Working Draft Additional Environmental Commitments

This document collates the additional environmental commitments that were presented by TII to the MetroLink Oral Hearing.

2. Additional Commitments for the Project Design (Chapter 4 of the EIAR)

<p>Consultant</p> <p></p>	<p>Drawing N°</p> <p>ML1-JAI-ARD-ROUT_XX-DR-Y-01001</p>	<p>Plan Drawing N°</p> <p>ML-LN O-01</p>	<p>Scales Original Size A1 1:1000</p>	<p>Sheet 1 of 19</p>

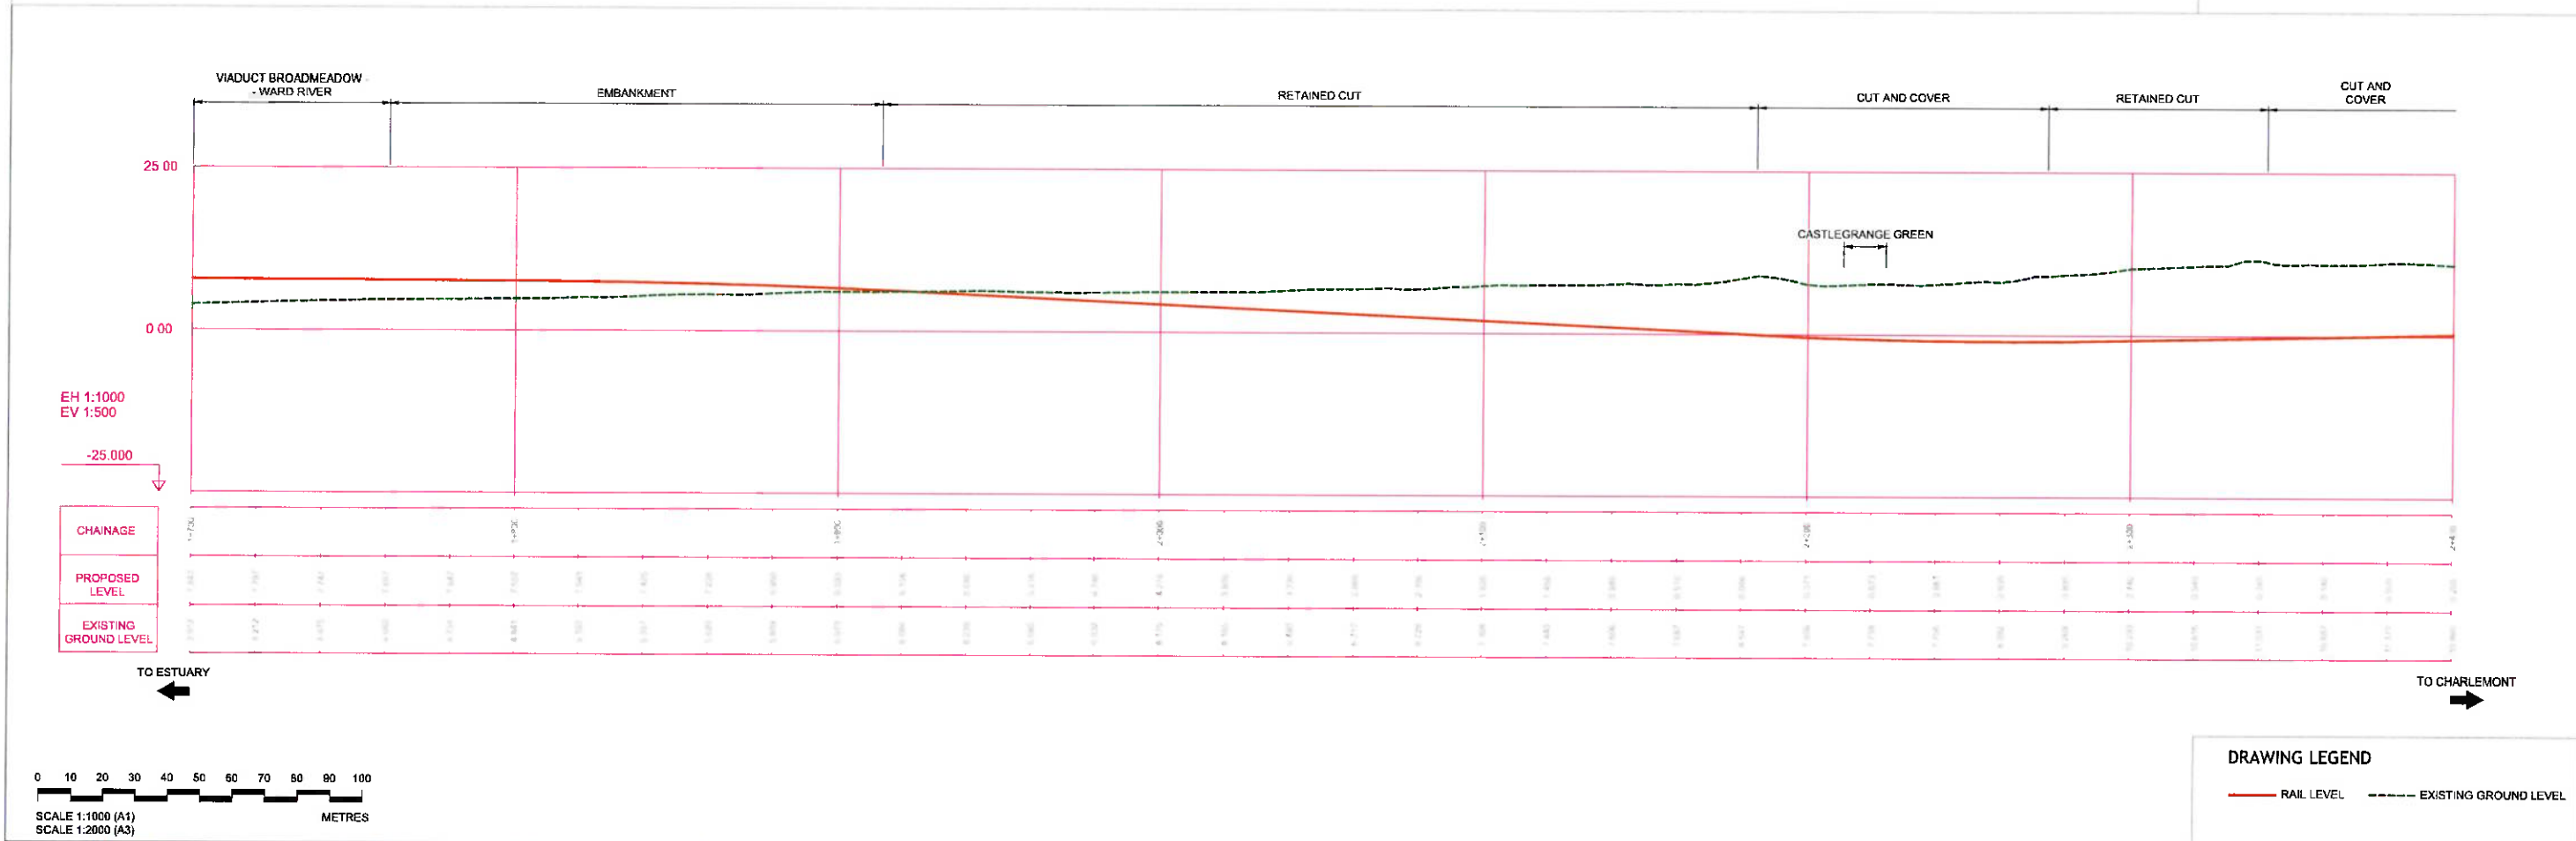
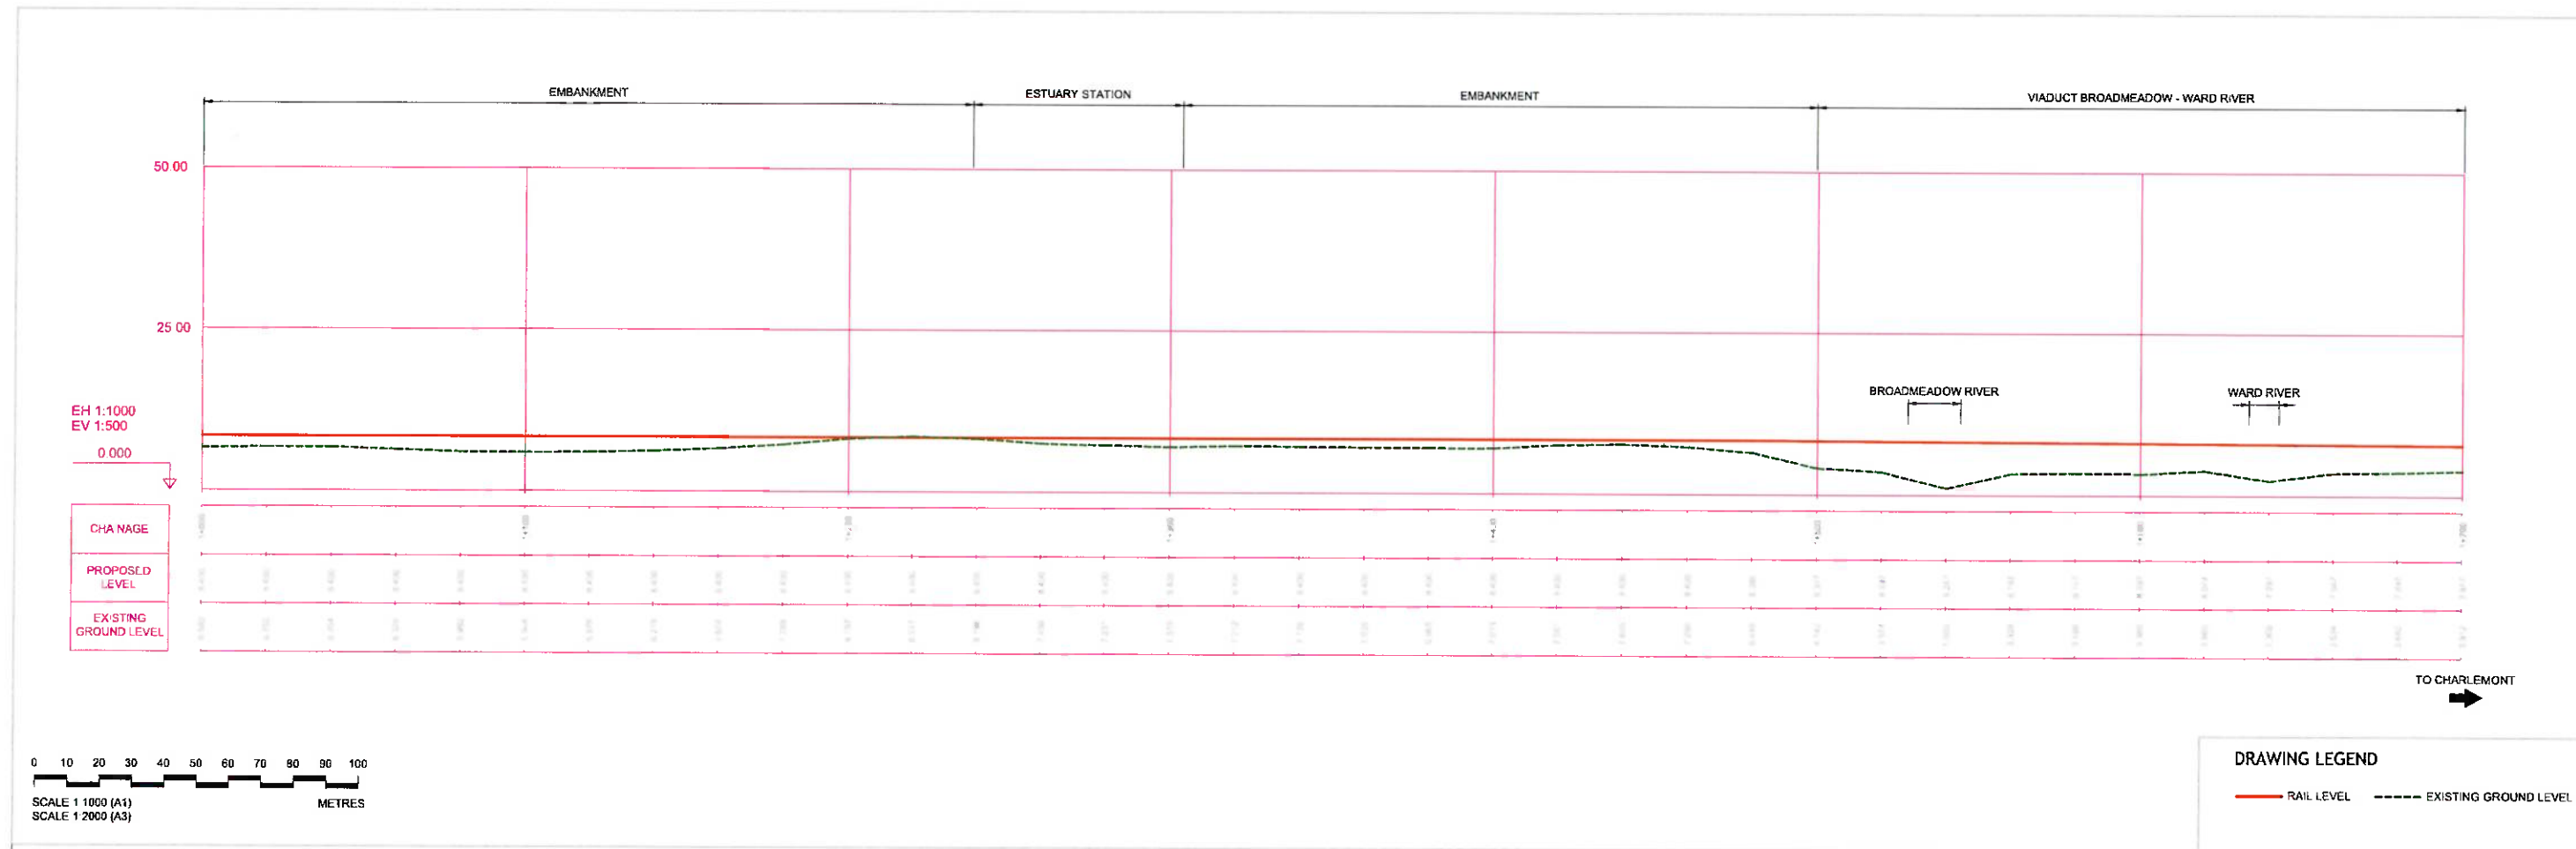
2.6	An additional 30m of cut and cover tunnel replacing retained open cut at Seatown Villas.	Seatown Villas, Swords	ML1-JAI-ARD-ROUT_XX-DR-Y-01001 ML1-JAI-ARD-ROUT_XX-DR-Y-03011 ML1-JAI-ARD-ROUT_XX-DR-Y-03012

Drawing N°: ML1-JAI-URD-ROUT\_XX-DR-Y-01056

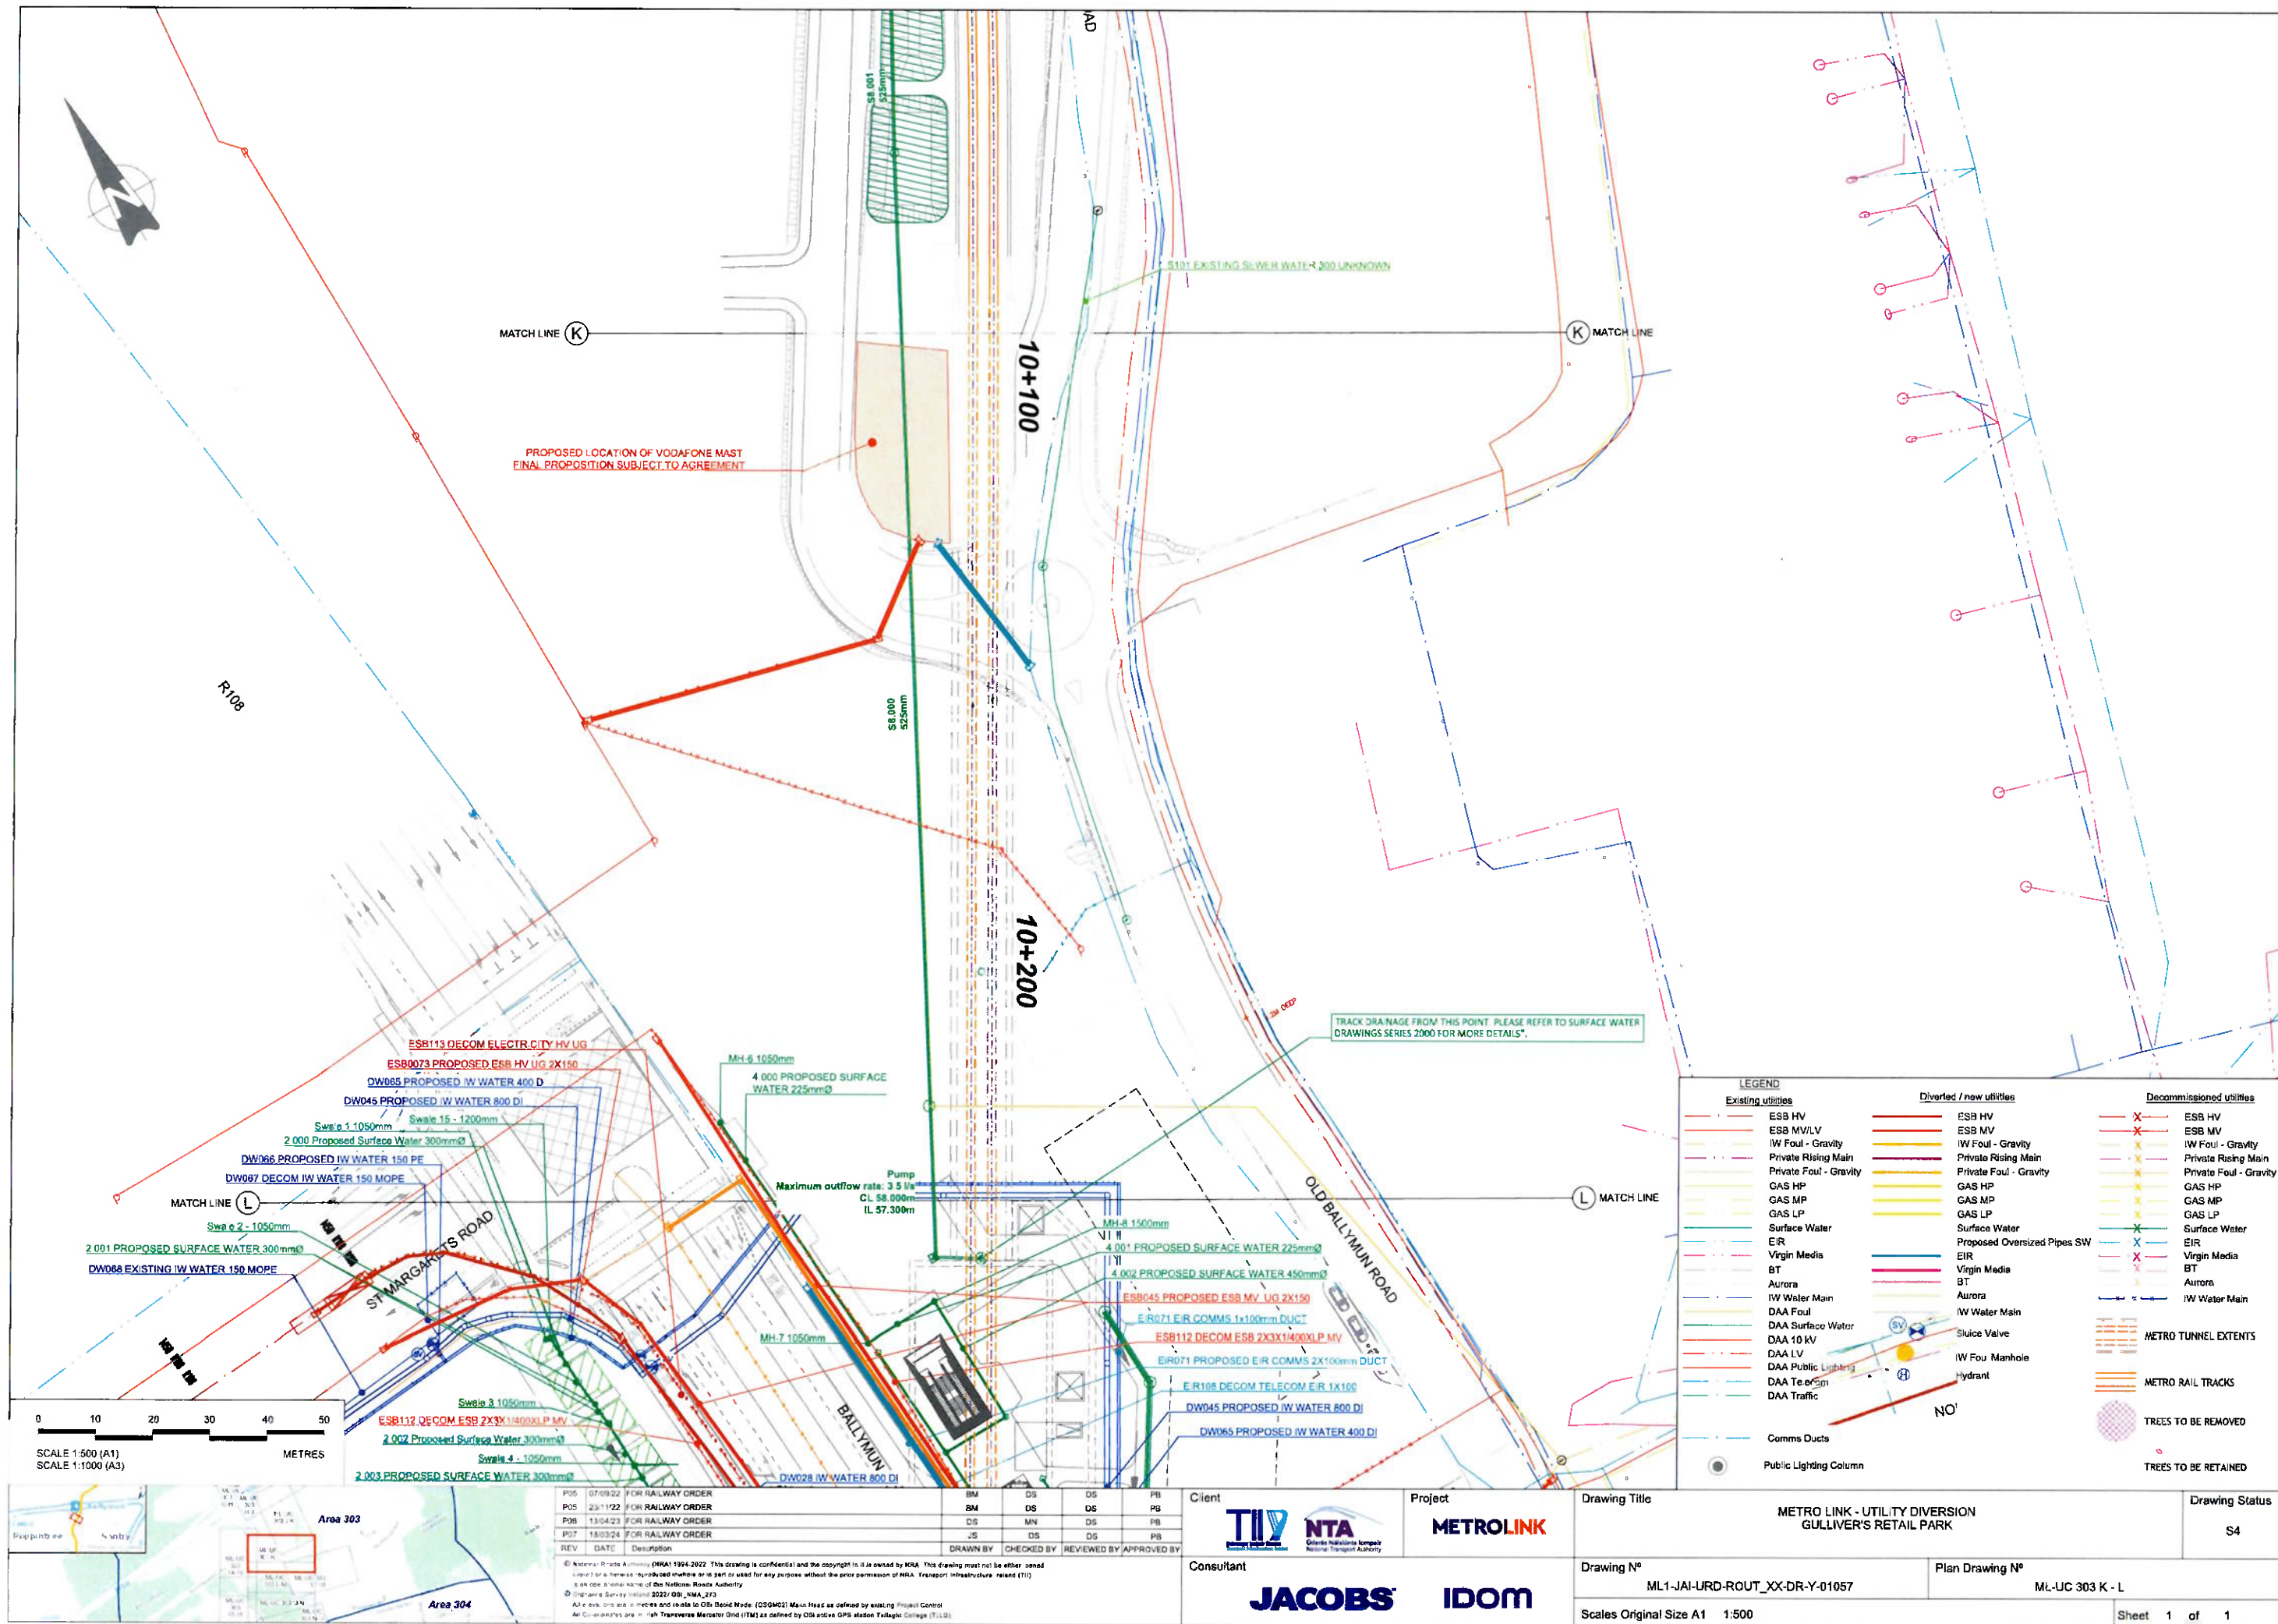
2.21	Signage will not be affixed to the glass façade on the canopy at Mater Station	Mater	N/A
2.22	<p>Gullivers Retail Park (Northwood) - revised roundabout design to reduce permanent landtake.in accordance with the maps appended below:</p> <p>ML1-JAI-ARD-ROUT_XX-DR-Y-03057</p> <p>ML1-JAI-ARL-SC07_GF-DR-Y-00114</p> <p>ML1-JAI-URD-ROUT_XX-DR-Y-01056</p>	Northwood	<p>ML1-JAI-ARD-ROUT_XX-DR-Y-03057</p> <p>ML1-JAI-ARL-SC07_GF-DR-Y-00114</p> <p>ML1-JAI-URD-ROUT_XX-DR-Y-01056</p>
